Permit number: 2208-189
Project: Kahn Residence
Project Address: 4205 85th Ave SE, Mercer Island, WA 98040
Parcel # 261790-0005

Subject: *Response to City of Mercer Island Plan Revision Review Comments*

Revisions  
 Drawn **DFP** Checked  
 Date **JULY 18, 2022**  
 Sheet  
**S1.2**  
 Scale Job

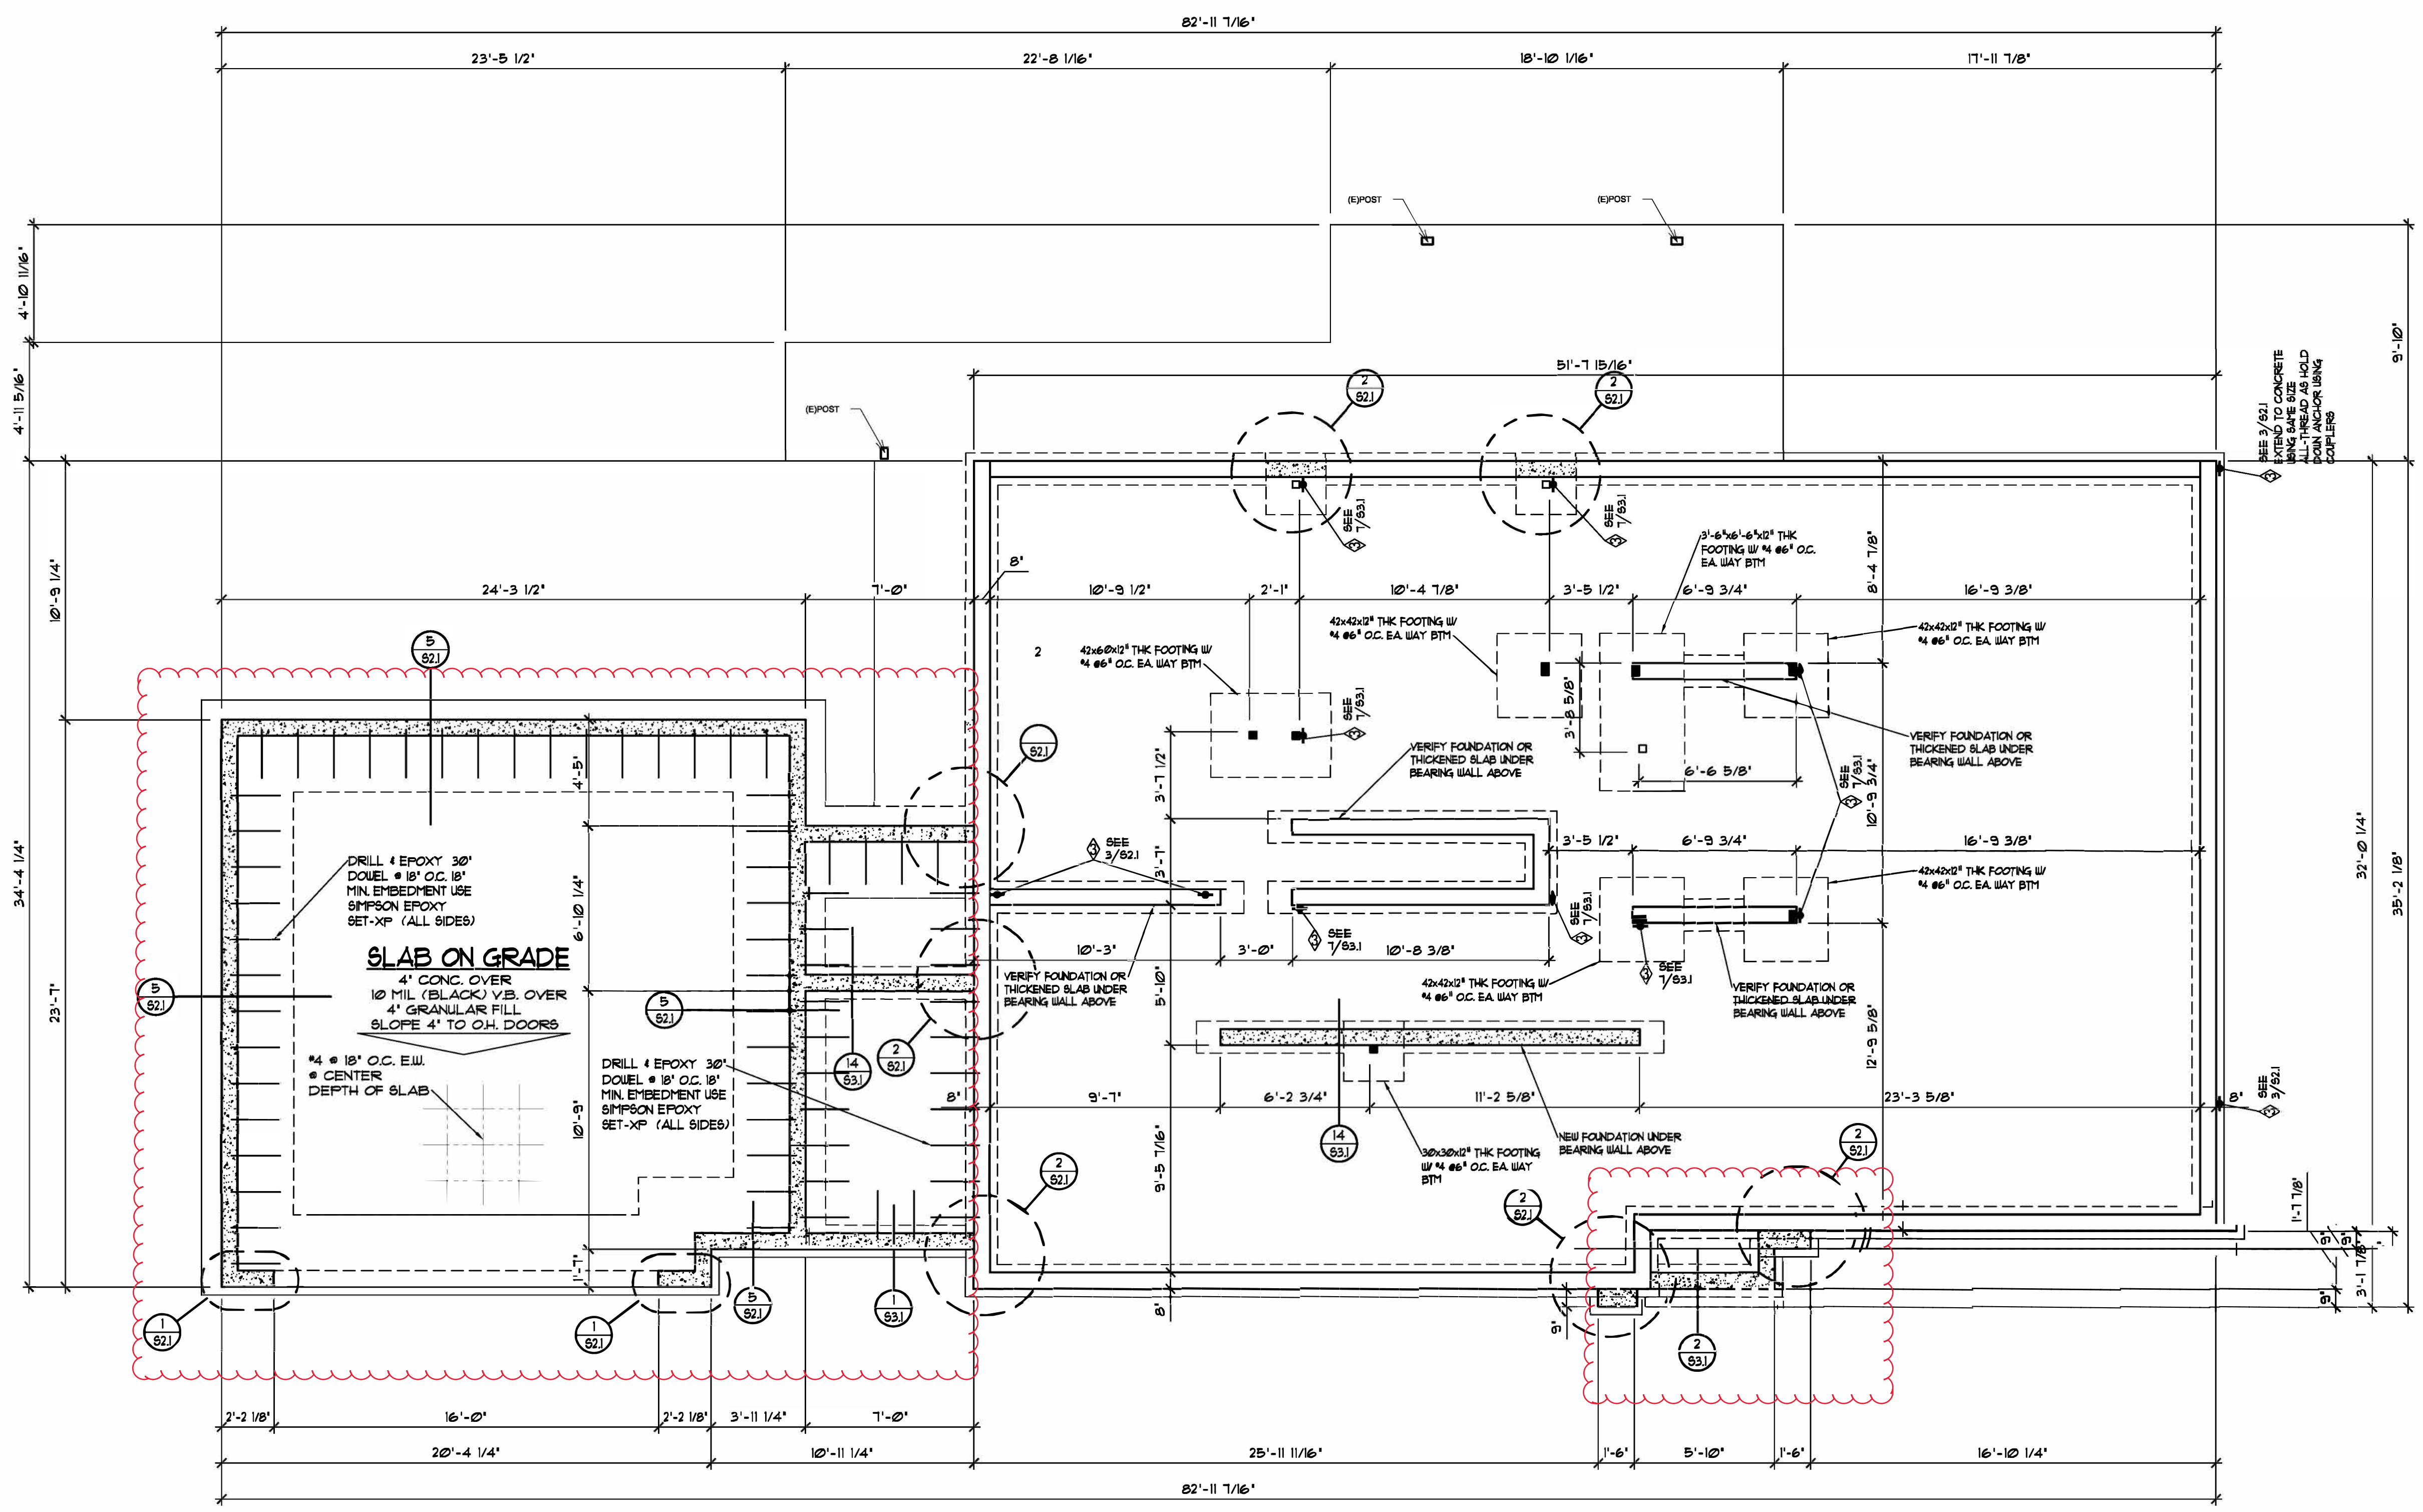
1. *Registered design professional is required to review - and - date and sign (stamp) drawings with changes.*
 - *This can be done with a letter referencing this set.*
 - *Or alter the plans with a key referencing the removed scope with an updated date.*

Narrative: The approach of a cloud is okay but the engineer needs to date and sign this set.

Sheet S1.2 Foundation Plan

- **The proposed garage has been removed from the scope of work, and the existing carport will remain unchanged.**
- **The proposed entry has been removed from the scope of work.**
- **The proposed foundation changes at the garage/carport and entry will not be implemented.**
